Ribble Valley Borough Council

App no: 25.0098

Address: Unit 13 Mitton Road Business Park Mitton Road Whalley BB7 9YE

Proposal: Change of use from light industrial (B1) to sui generis. Proposed opening hours 9.00 am to 7.00 pm (Monday to Friday) and 9.00 am to 4.00 pm on Saturdays

29 JUL 2025 Scale 1:100

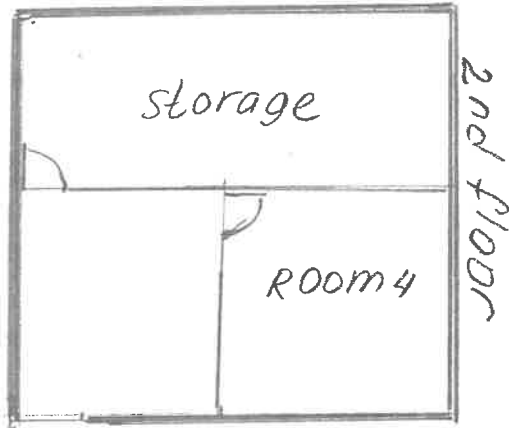
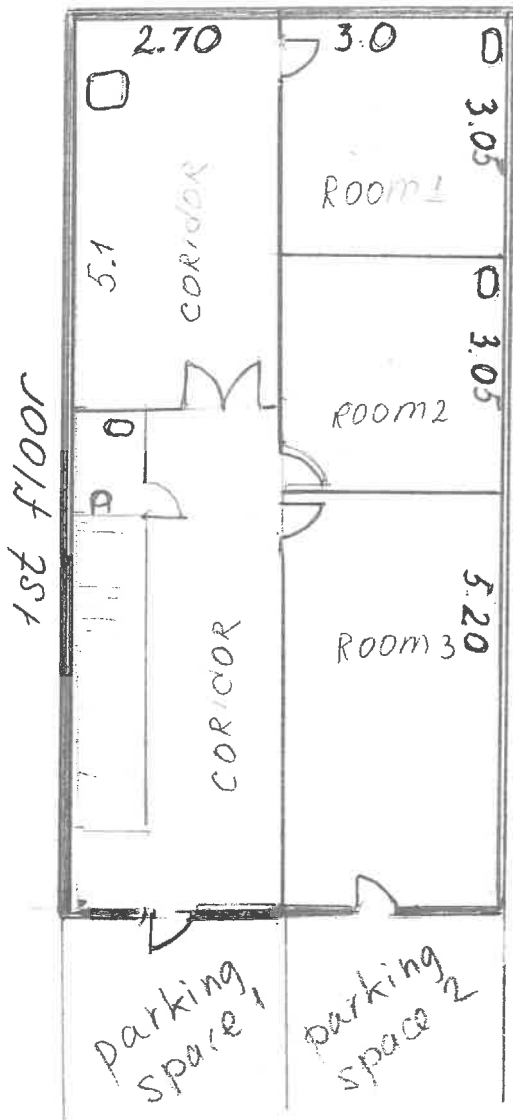
The floor plan shows 4 treatment rooms. The floor area is shown as 63.84sqm ground floor and 11 sqm mezzanine, totalling 75sqm approximately.

The professional services parking standard is the same as the former B1 standard at 1 space per 30sqm, equating to 2.5 spaces for a floor area of 75sqm. The health/medical standard is higher at 4 spaces per consulting room, equating to 16 spaces.

In this case the applicant states that there are 2 staff on site at any one time, there are no customer numbers stated however other similar business applications would suggest up to 4 customers on site (2 being attended and 2 waiting) this totals 6.

This would require 4 car parking spaces in the communal area. There is no evidence to suggest that there is a shortage of overspill car parking at the site currently which is resulting in a highway safety matter.

Lancashire County Council acting as the Highway Authority does not raise an objection regarding the proposed development and are of the opinion that the proposed development will not have a significant impact on highway safety, capacity or amenity in the immediate vicinity of the site.
